Tween Bridge Solar Farm

8.25 Applicant Responses to Stakeholder Responses to ExQ2

Document Reference: 8.25

Deadline 5 August 2026

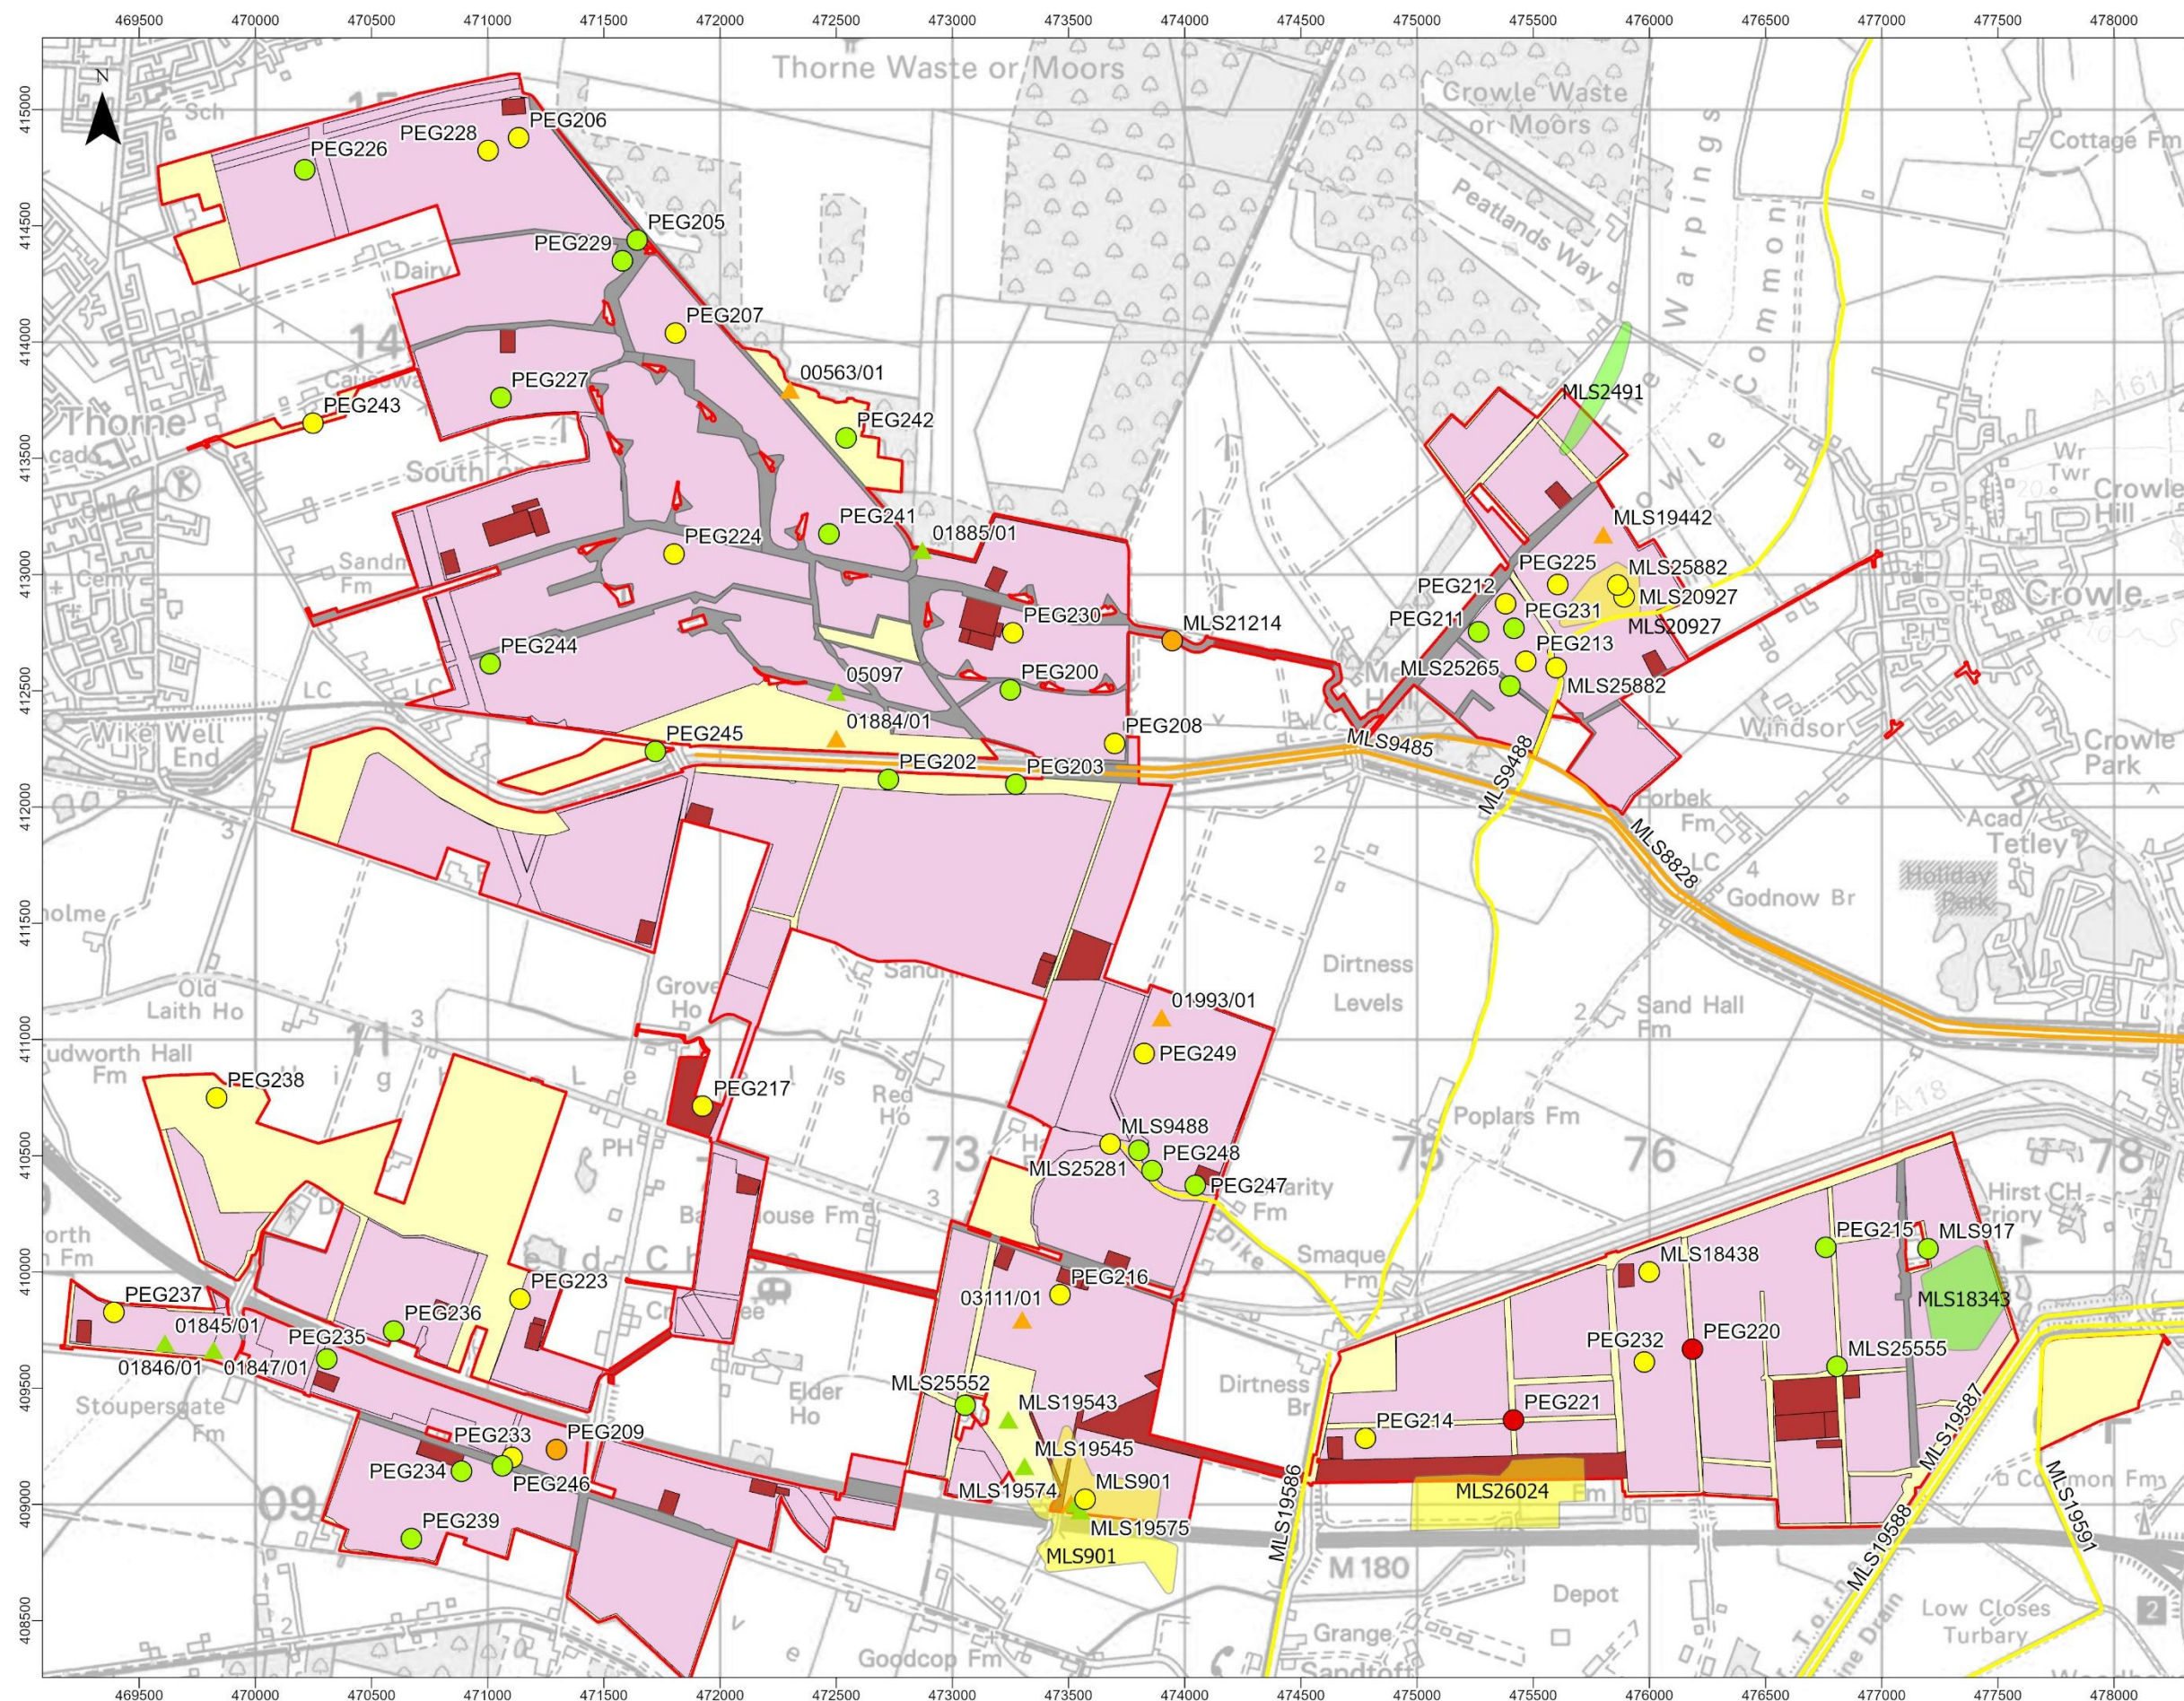
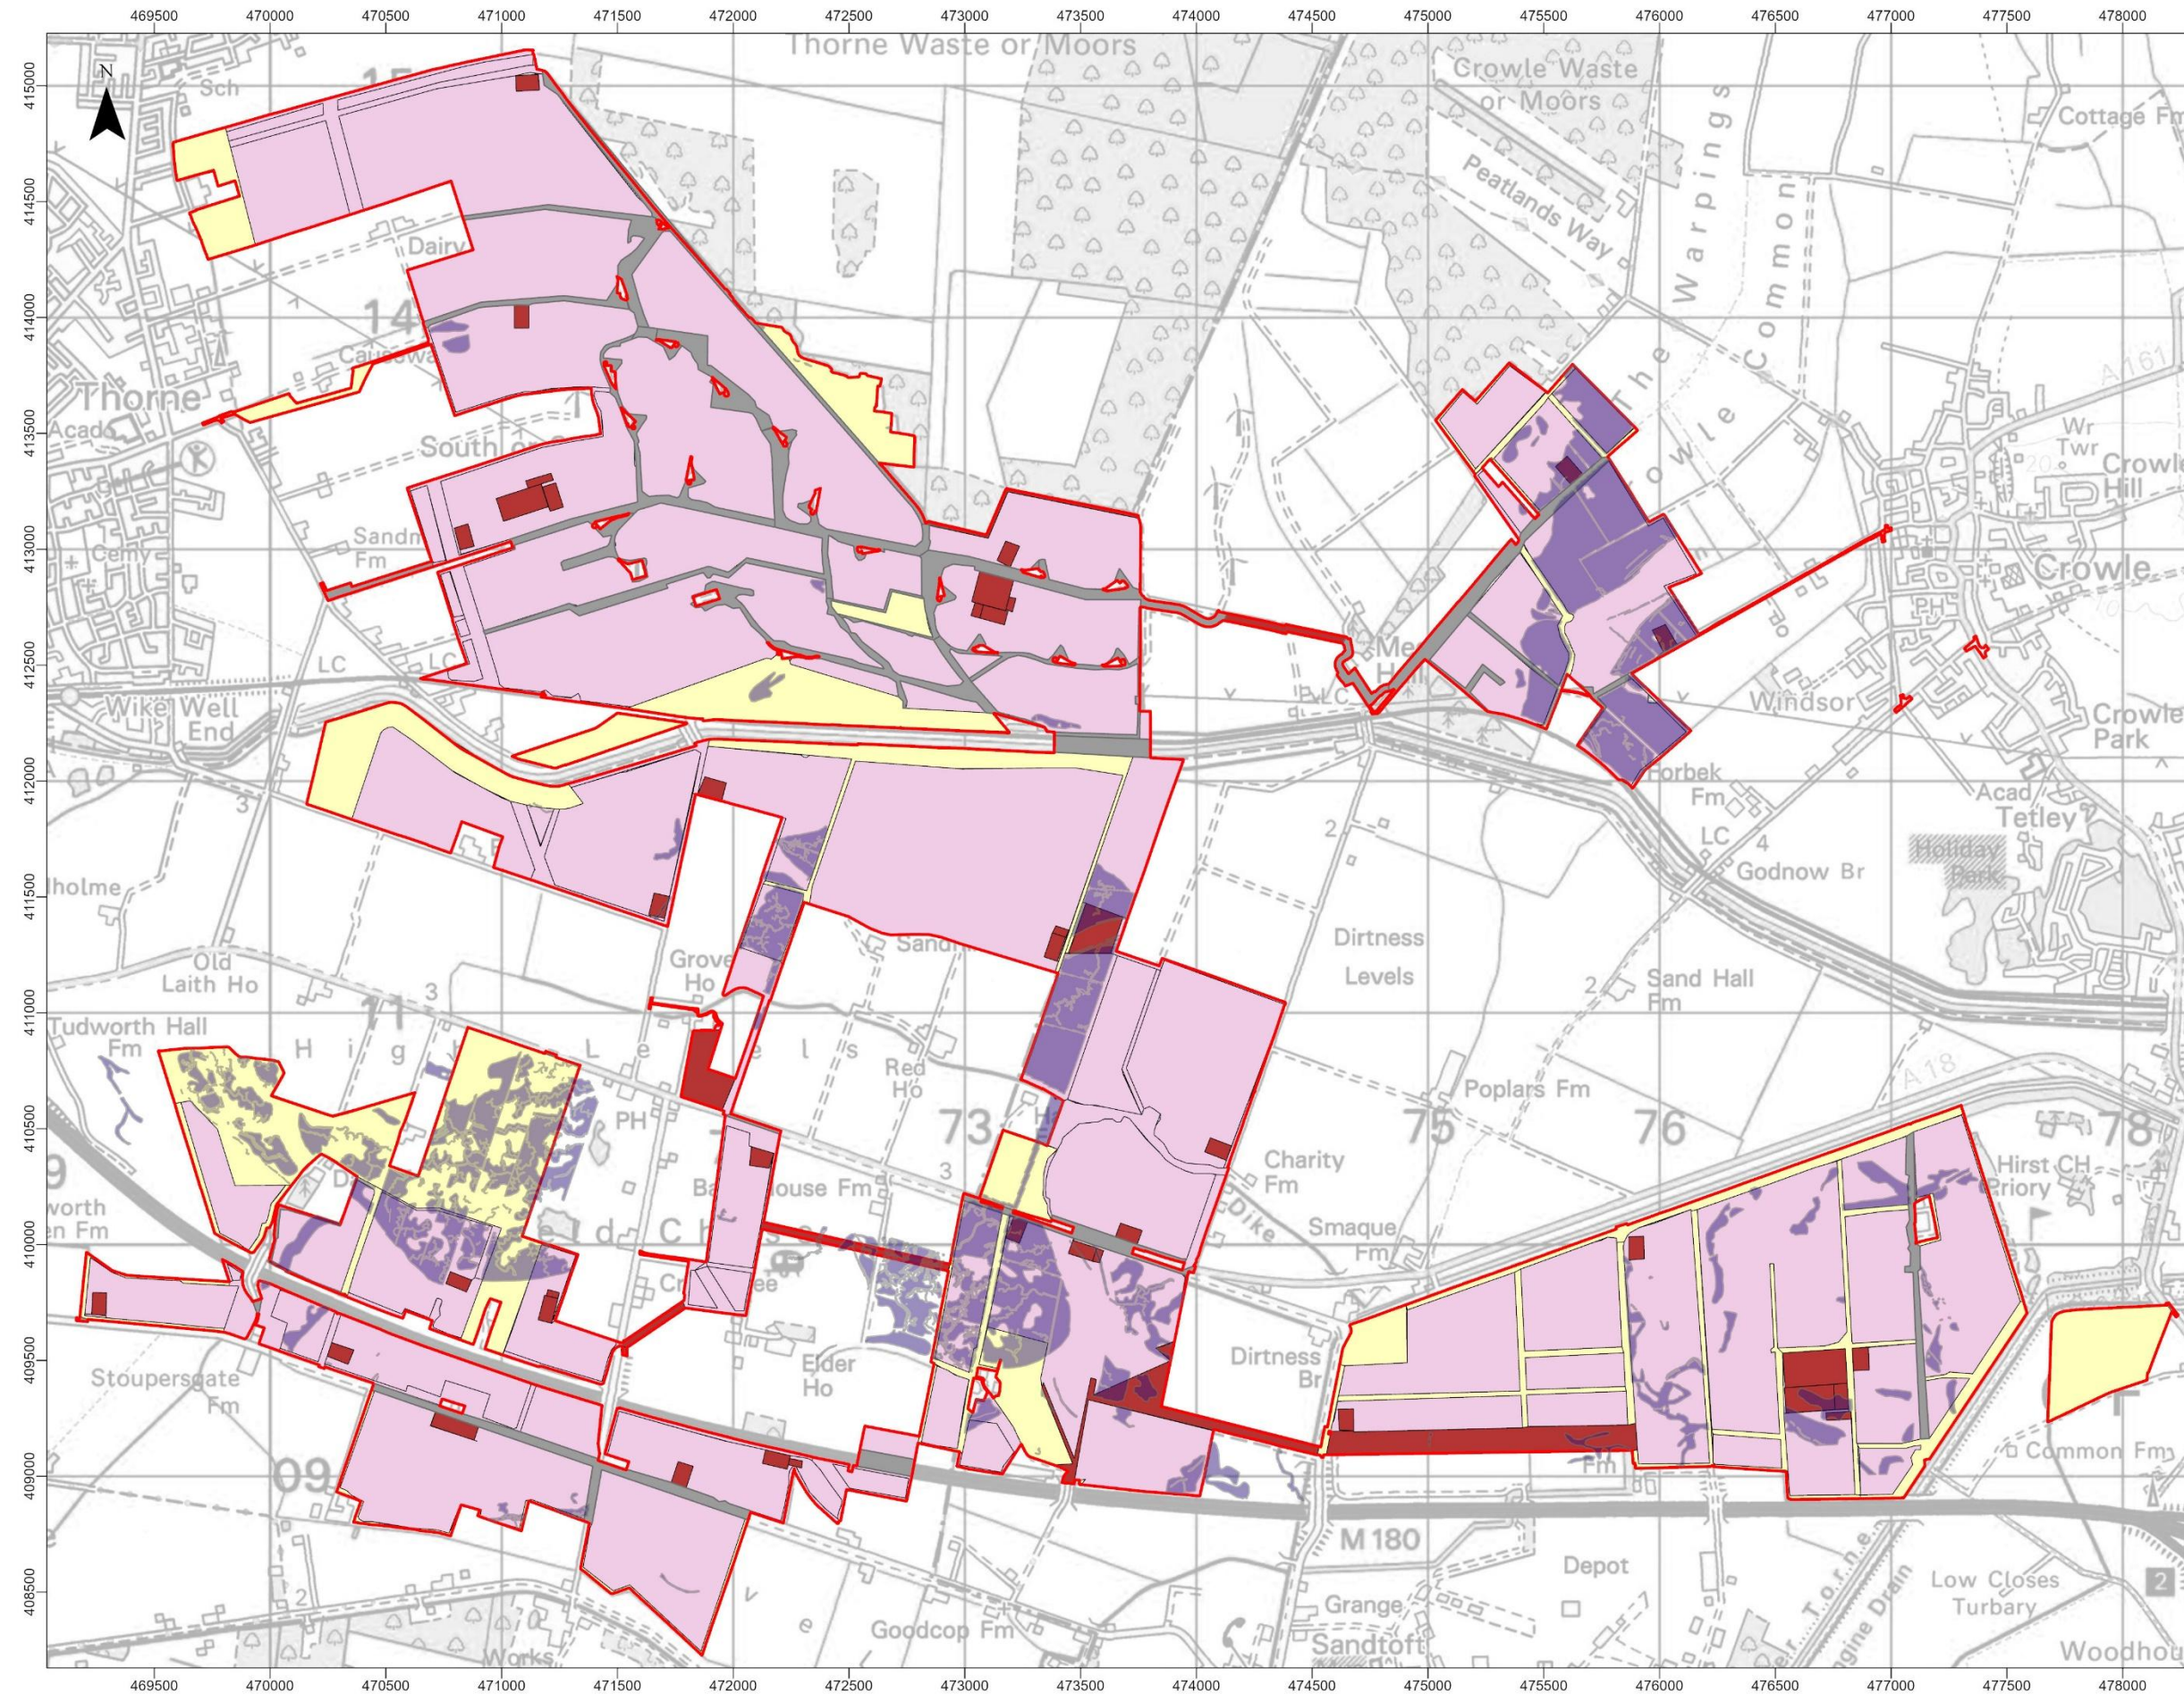
Q2.6.3	Archaeology CDC's LIR [REP1-062] paragraph 8.30 states in part: 'In order for appropriate weight to be given to the effects of the proposals on the significance of any affected heritage assets, it will be necessary for the Applicant to demonstrate that sufficient flexibility remains within the scheme design and the mitigation options to respond to archaeological discoveries made and to avoid unnecessary harm.' Could CDC please elaborate and explain what this would look like in practice? Could the applicant also provide a response?	CDC's position, as set out in the LIR, is that sufficient weight can only be given to the potential effects on heritage assets where there is a clear understanding of both: • the likely archaeological significance of different parts of the Site; and • the extent to which individual scheme components can be modified or relocated in response to archaeological discoveries. While the Applicant has identified design flexibility as a characteristic of solar farm development, it is recognised that the degree of flexibility is not uniform across all elements of the scheme. Some components may be more constrained in their location or may result in greater levels of ground disturbance than others. CDC therefore considers that the Applicant should demonstrate how the anticipated archaeological significance of different areas relates to the flexibility available within the scheme design and how this relationship would inform the selection of appropriate mitigation measures should archaeological remains be identified. In practice, the datasets gathered for the heritage baseline suggest the varying archaeological sensitivities across the order	The Applicant is committed to continuing engagement with SYAS on behalf of CDC to seek agreement on the topics outlined in this comment. The Applicant considers that the revised zoning plan provided within 6.3.8.6 Appendix 8.6 Outline Archaeological Strategy [Document Reference 6.3.8.3 Revision 4], which has been provided at Deadline 5 following feedback from SYAS and NLC, will be pivotal in articulating the zones of archaeological sensitivity that arise from the construction impacts and the identified archaeological/geoarchaeological potential of different areas within the Order Limits.

Ref	Question	CDC's response	Applicant's response
		limits. These can be used as a proxy for significance and, when mapped against the different impacts of the components of the scheme, produce a zoning plan which spatially defines the anticipated magnitude of effects. This spatial definition provides a mechanism for understanding the degree of design flexibility available within particular locations of the scheme and therefore the extent to which adverse effects on archaeological remains can be avoided through design changes or whether alternative mitigation measures would be necessary.	
Q2.6.4	Archaeology Could the applicant please provide a response to the assertions made at paragraphs 8.19 to 8.29 of CDC's LIR [REP1-062]? Specifically, could the applicant explain whether it considers that it has sufficiently taken a holistic approach to the consideration of below ground heritage assets and the extent to which they are likely to be present? Please could both Councils and the applicant also provide an update on discussions with regard to the extent of archaeological works to be secured post consent (in the event that consent is granted)? Any disagreement should be clearly explained with reasons given.	The broad framework for post-consent archaeological works is currently set out within the oAMS [REP2-045]. However, detailed discussions regarding the precise extent of archaeological works that may ultimately be required post consent have not yet been concluded. Discussions between the Applicant, SYAS (on behalf of CDC) and NLC have instead focused on the development of the zoning plan as a means of understanding the varying archaeological sensitivities and potential impacts across the Order Limits, and thereby informing a proportionate approach to any future archaeological works. Following discussion at ISH2, the Applicant revised the zoning plan which had been submitted as part of the updated oAMS [REP2-045] to include two figures. Those figures were subsequently discussed at a meeting between the Applicant, SYAS and NLC. During that meeting, SYAS provided detailed comments regarding the incorporation of existing archaeological datasets and other baseline evidence, with the aim of enabling the zoning plan to better illustrate the varying potential magnitude of effect across the Order Limits. It was agreed that a further iteration of the zoning plan would be prepared and submitted at Deadline 5. Discussions regarding the detailed scope of post-consent archaeological works remain ongoing and will continue to be informed by the development of that zoning plan.	The Applicant is committed to continuing engagement with SYAS on behalf of CDC to seek agreement on the topics outlined in this comment. As noted, the Applicant considers that the revised zoning plan provided within 6.3.8.6 Appendix 8.6 Outline Archaeological Strategy [Document Reference 6.3.8.3 Revision 4], which has been provided at Deadline 5 following feedback from SYAS and NLC, will be pivotal in articulating the zones of archaeological sensitivity that arise from the construction impacts and the identified archaeological/geoarchaeological potential of different areas within the Order Limits.
